**KIRKLEES METROPOLITAN COUNCIL
INVESTMENT & REGENERATION SERVICE**

Reference No: 2020/44/90862/W

Site Address: Kingsgate Centre, King Street, Huddersfield, HD1
2QB

DECISION – Discharge of Conditions-Refused

Condition No 08

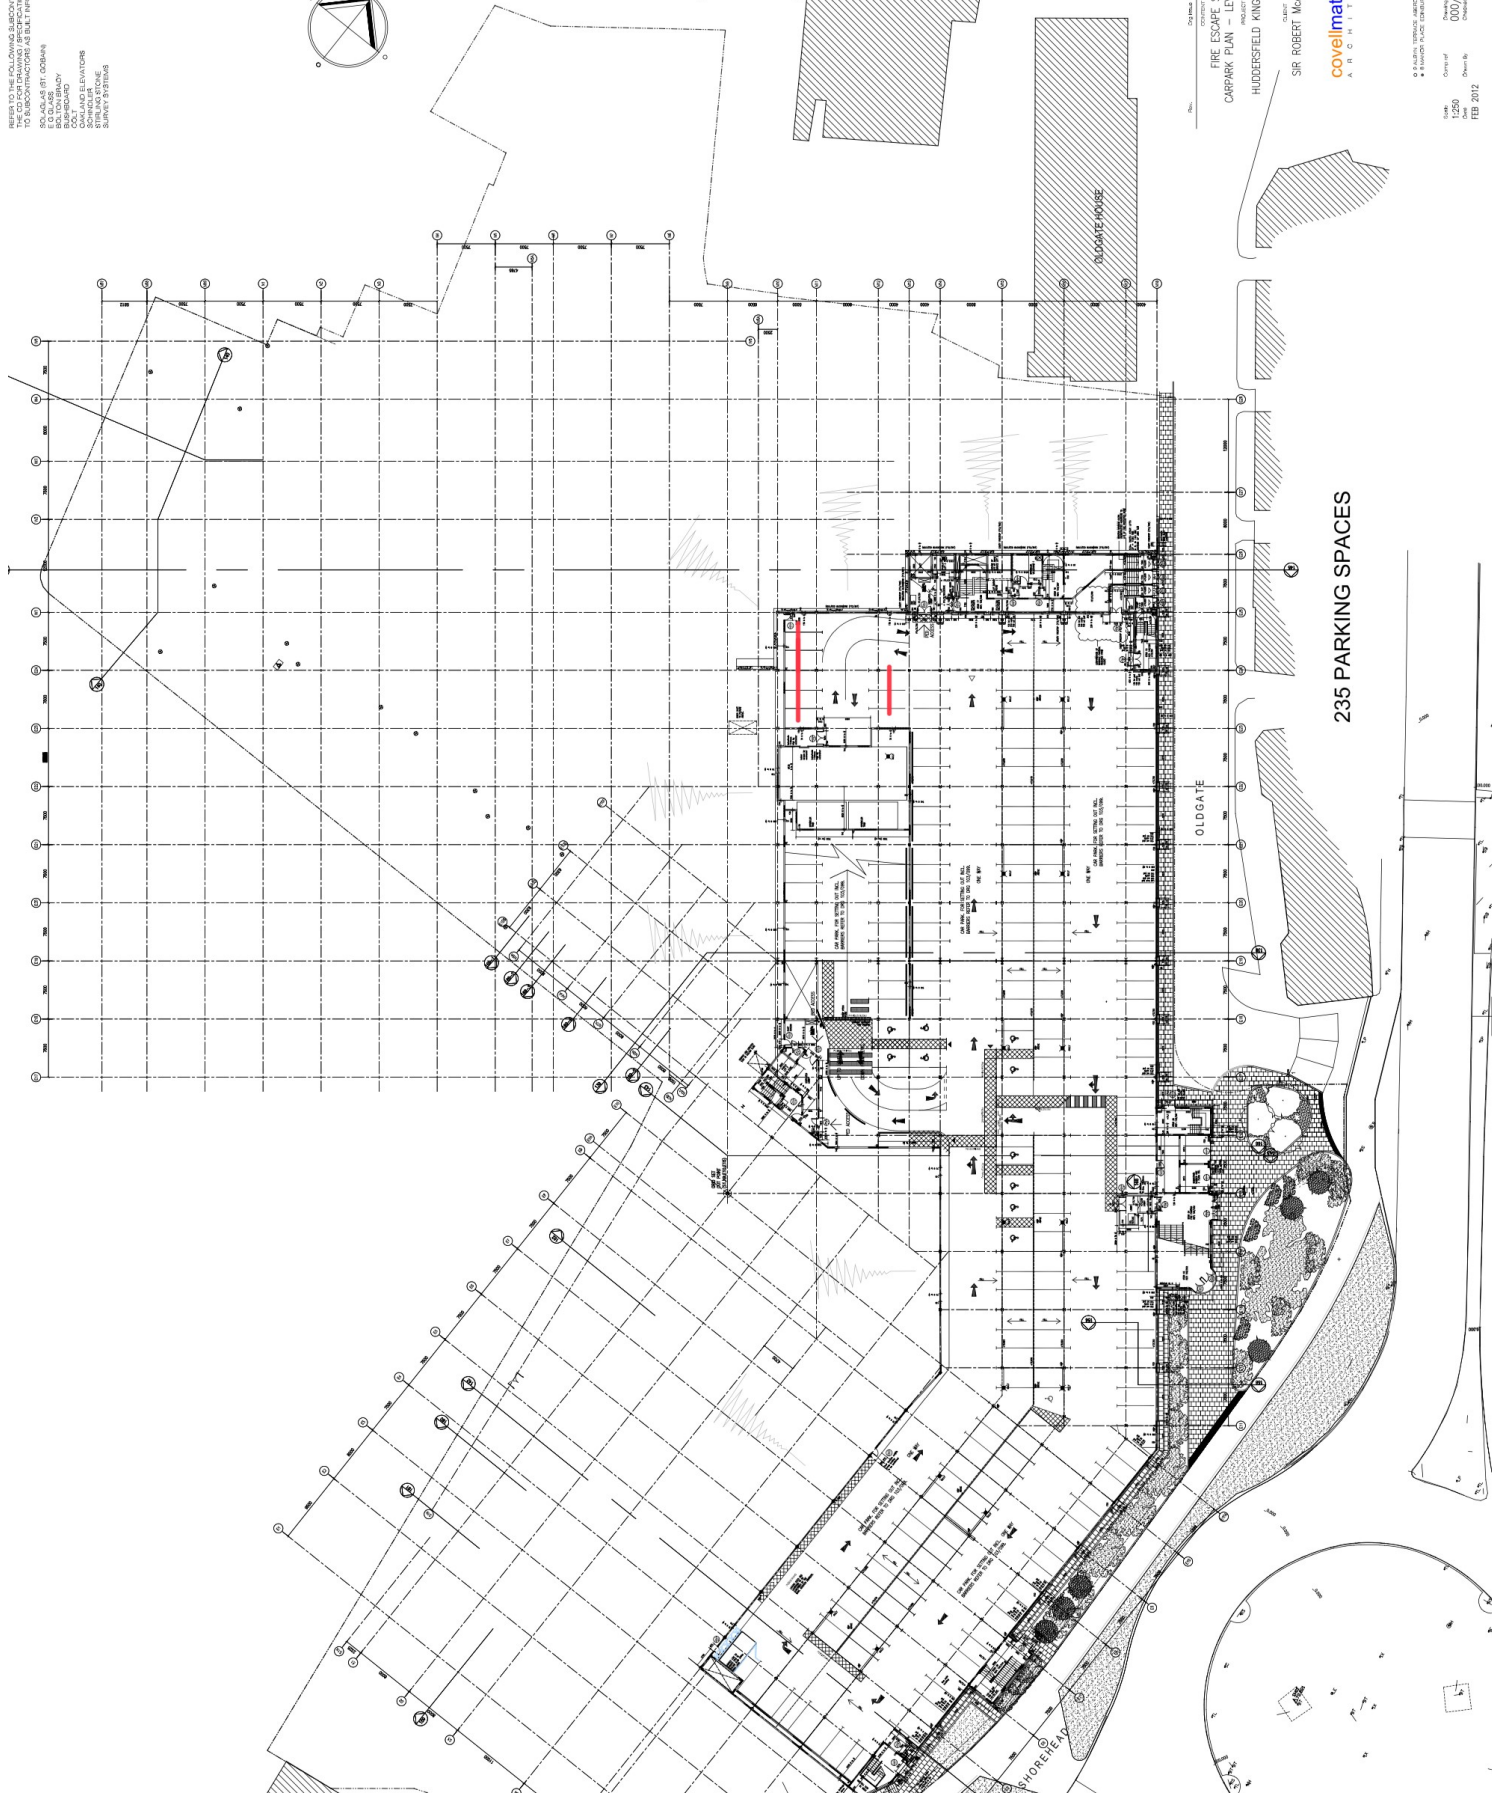
Officers accept the logic of 176 parking spaces as a starting point. However, officers would round 5% of 176 (8.8) to 9 units. Furthermore, there is no proposed trigger point for the remaining 5% of units.

Notwithstanding the above, the proposed 8 units are shown to be two different chargers that are each capable of providing a nominal 22kW per charging point. The use of Fast Charge units for the site, being a retail car park, is welcomed over slower alternatives. If it can be confirmed that all 8 units are to be 22kW units and would operate at their maximum speed, no additional charging points are sought.

It is understood that the car park is managed and that users are subjected to parking fees. It is therefore assumed that the parking bays served by the EV charging points will be managed in a way that prevents them being used by non-electric vehicles. Confirmation of how the spaces will be managed needs to be provided by the applicant.
